From: Michael Eastham
Sent: 24 April 2019 12:20
To: Planning.Responses
Cc: Lynnyrd Wolfe
Subject: FW: BN/59/18/DOC - Ashdown Vale Barnham - Retaining Walls
Attachments: Surface Water Drainage Maintenance. Barnham-Issue 3.pdf

From: Nick Dyde [REDACTED]
Sent: 24 April 2019 10:53
To: Laura Gibbons
Cc: Laura Humphries; Michael Eastham; Pete Hodgson
Subject: RE: Ashdown Vale Barnham - Retaining Walls

External Levels & Features Layout
Sheet 3 of 3

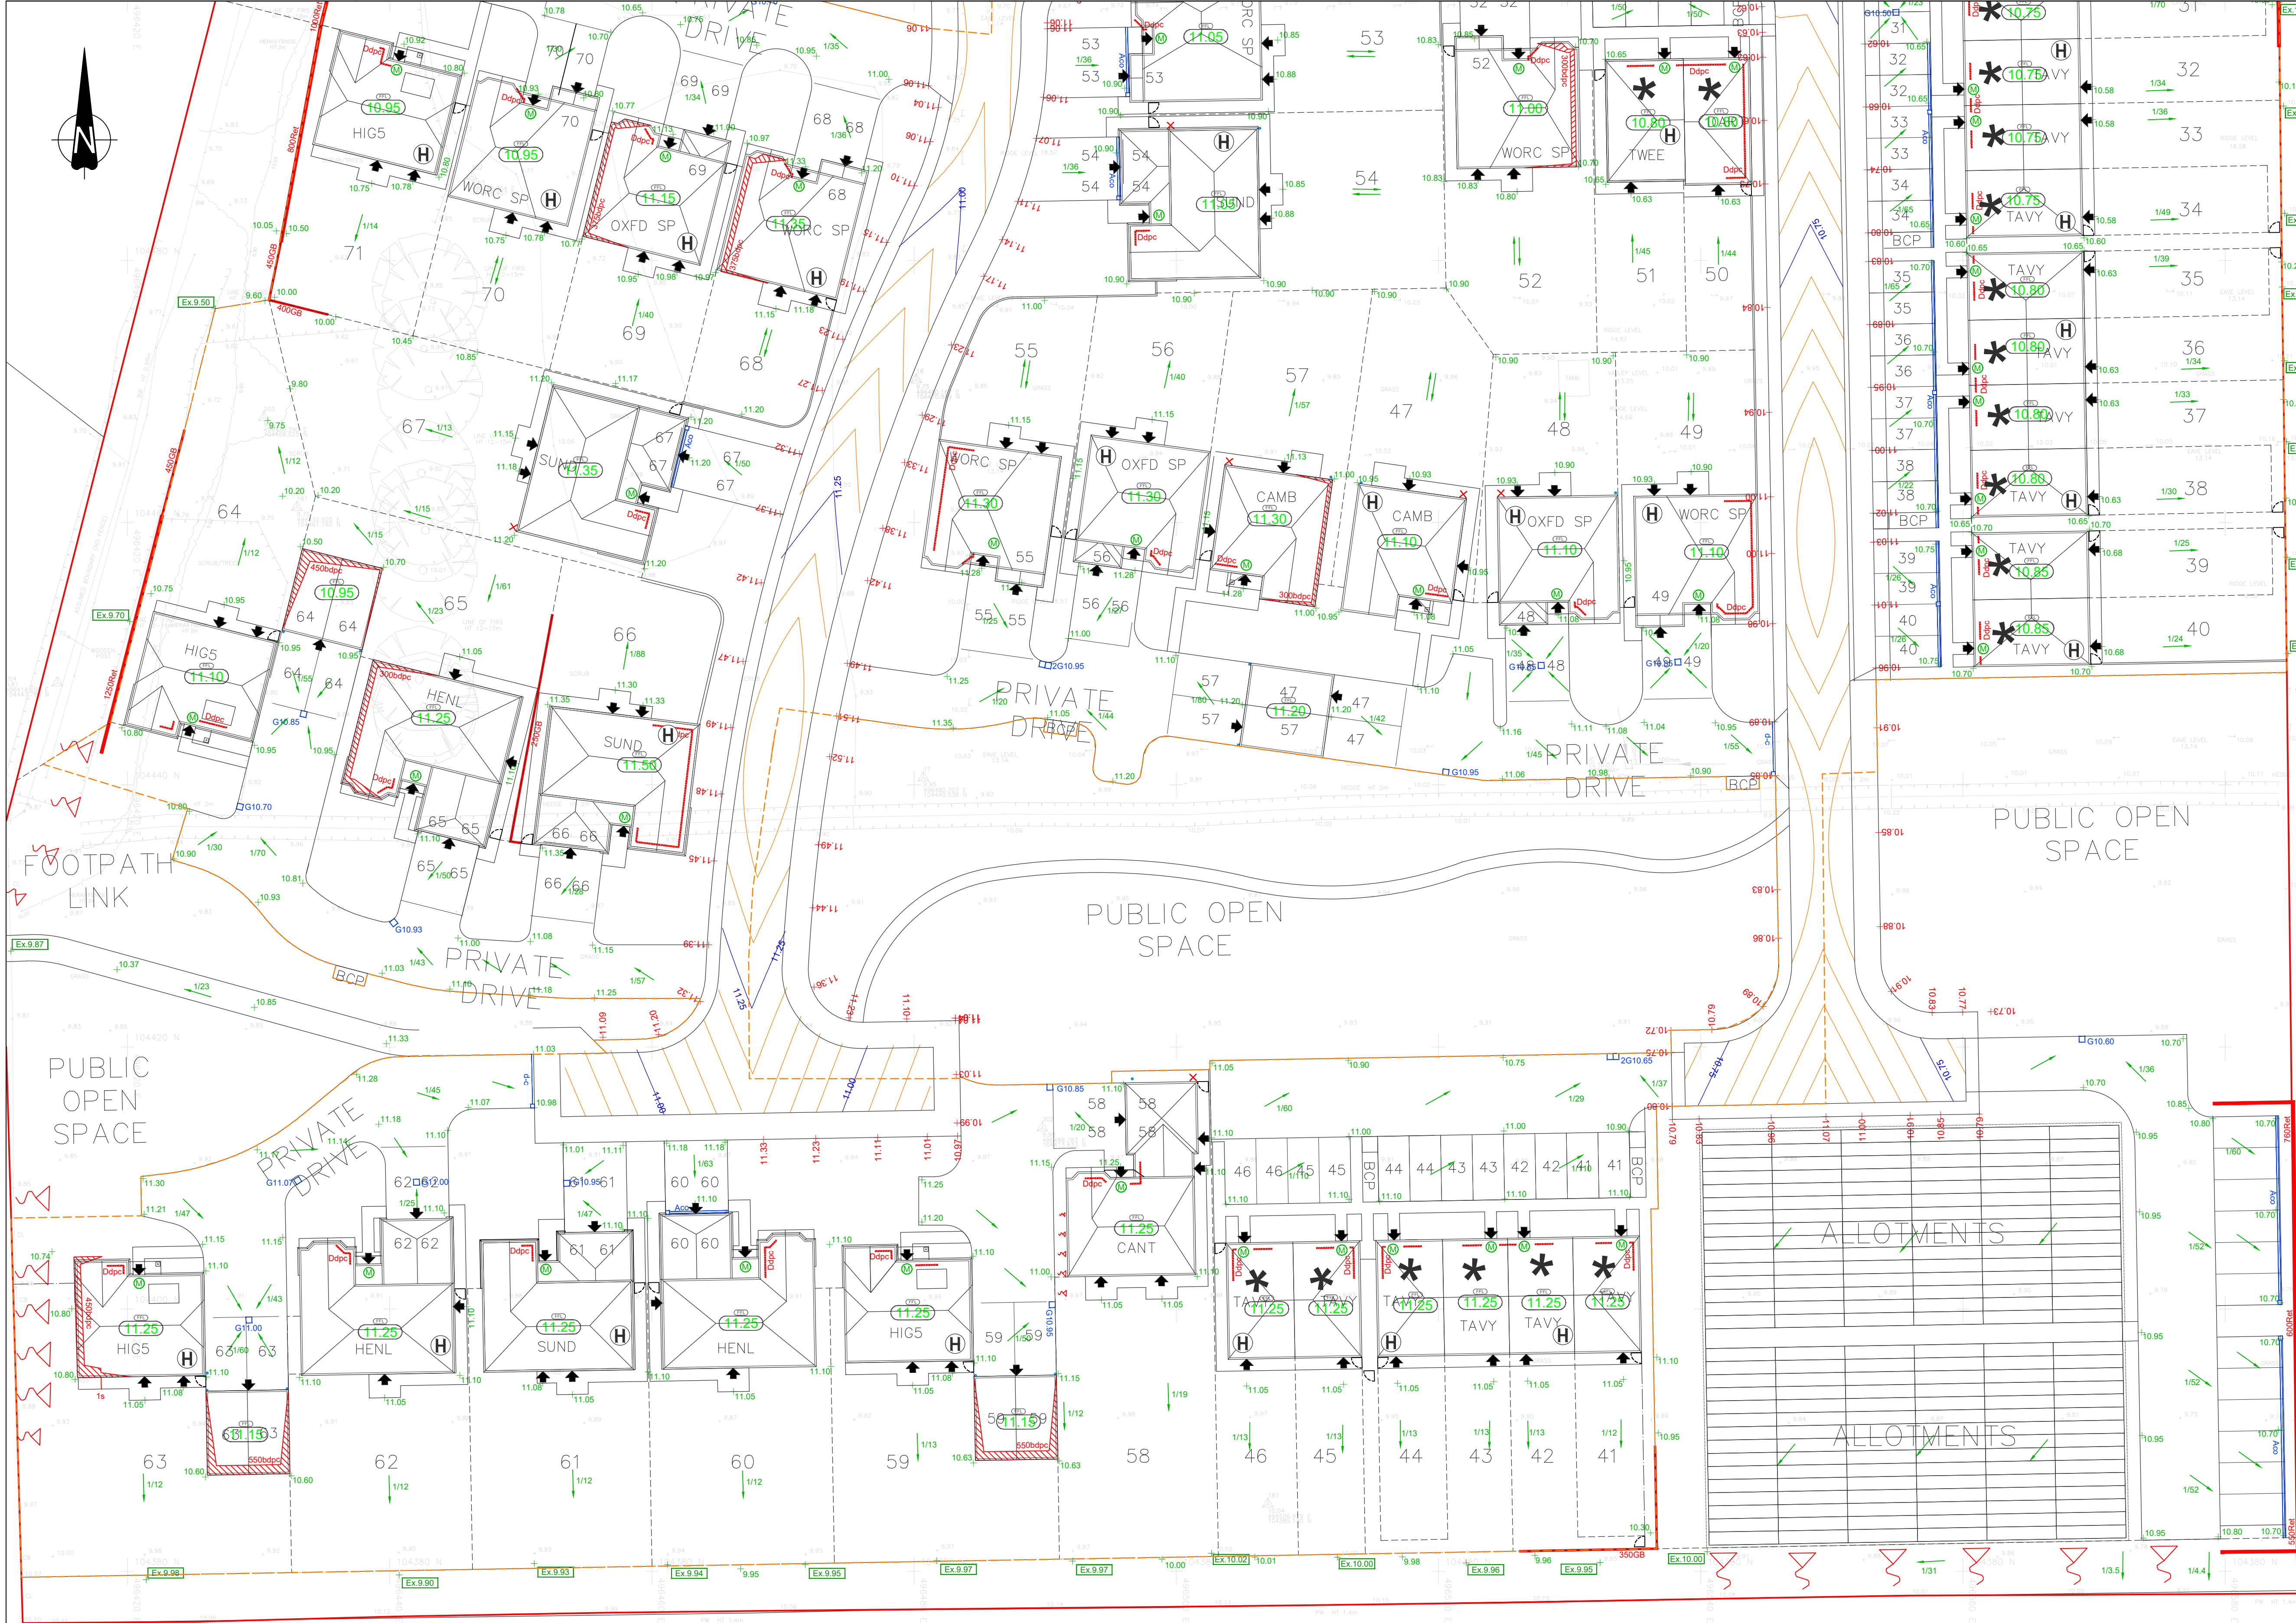
I note the plan states that the slope of gardens at 92-93 has increased where the retaining walls are no longer required. I would like to see a gravel margin included where any revised slopes are effectively directing surface water runoff to neighbouring land.

The proposed wall at plot 88 will be okay with the proposed gravel margin.

Please send through revised construction detail drawings and layout.

Following on from our discussion at the Arun District Council planning and drainage seminar, I have now looked into designing out the retaining walls, the attached sketch demonstrates my findings.

Ultimately it appears the majority of the walls along the western boundary can be designed out with the exception of plot 88. For this plot we propose to install a gravel margin on the low side of the wall to accommodate for flows discharging from the weepholes.
